Application for approval of matters reserved by condition imposed under P/12/14/ relating to condition 3 for landscape scheme.

Pagham Yacht Club Harbour/West Front Road, Pagham,

Arun District Council have decided to **REFUSE** details reserved by condition for the following reasons:

Drawing Title
**Proposed new perimeter
fencing
SITE and LAYOUT
PLANS.**

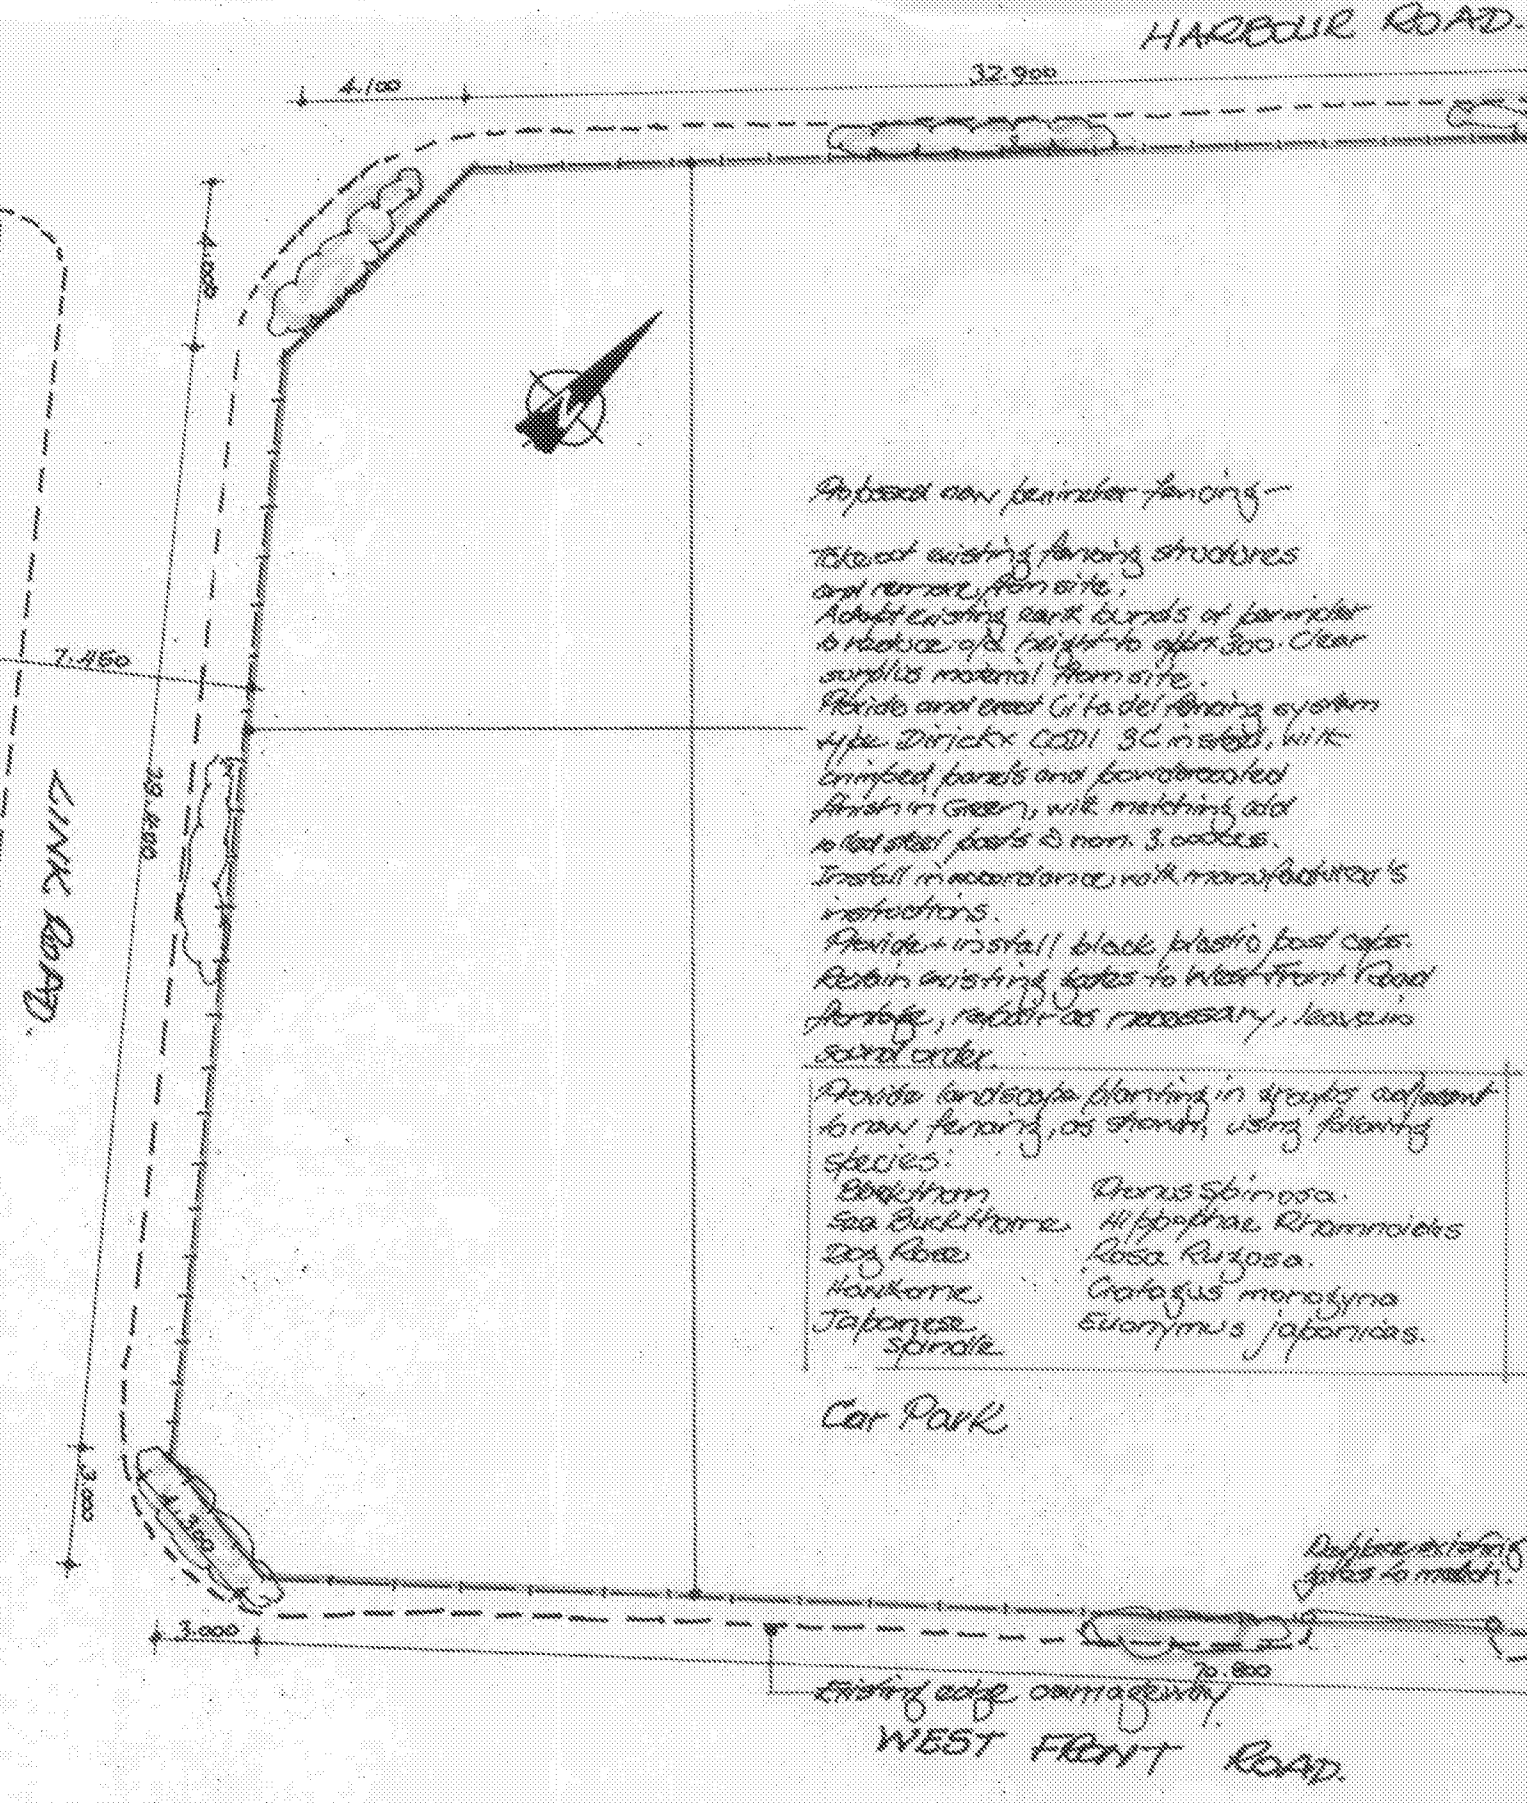
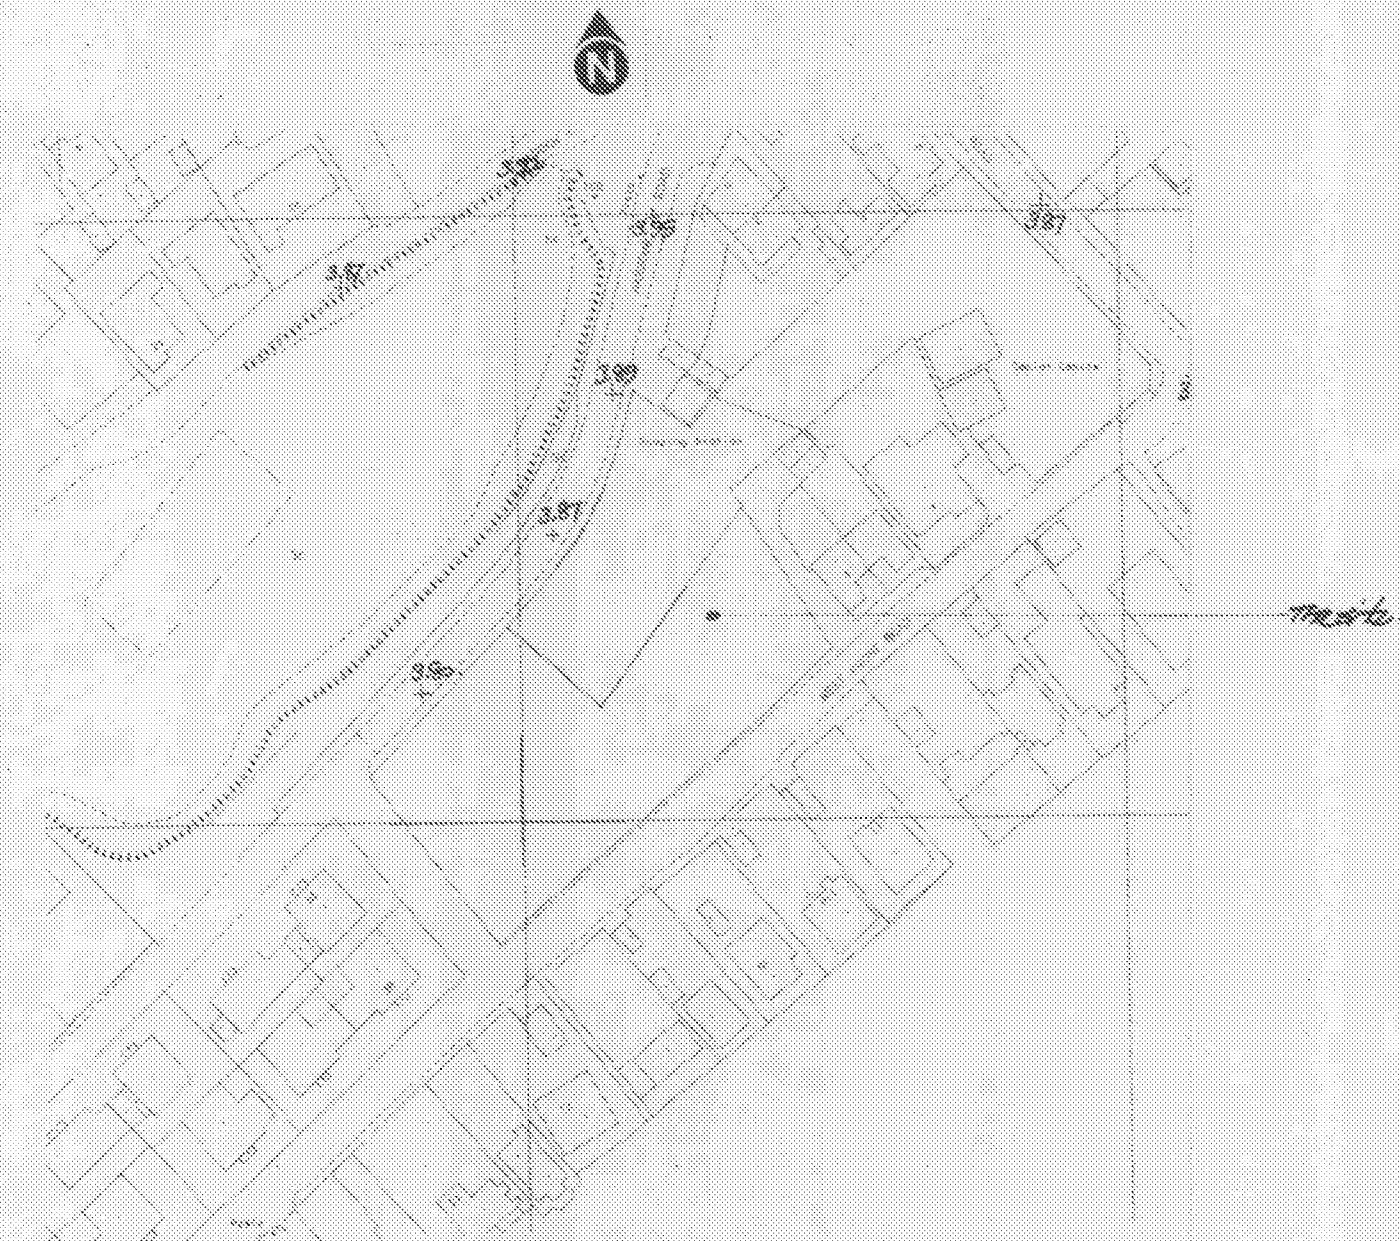
The details submitted in respect of the landscaping condition namely the drawing titled "Proposed new perimeter fencing - Site & Location Plans" Ref 14/02/01 Rev B is not considered to be acceptable and therefore does not satisfy the requirements of the condition.

You will recall that I received an objection to the landscaping scheme from our Greenspace team on 01 June 2015 and I forwarded this to you on 02 June. You replied on the 4th June to say that a revised scheme would be prepared but I have not received any further information.

The condition is not therefore discharged and I await a further application to discharge the condition.
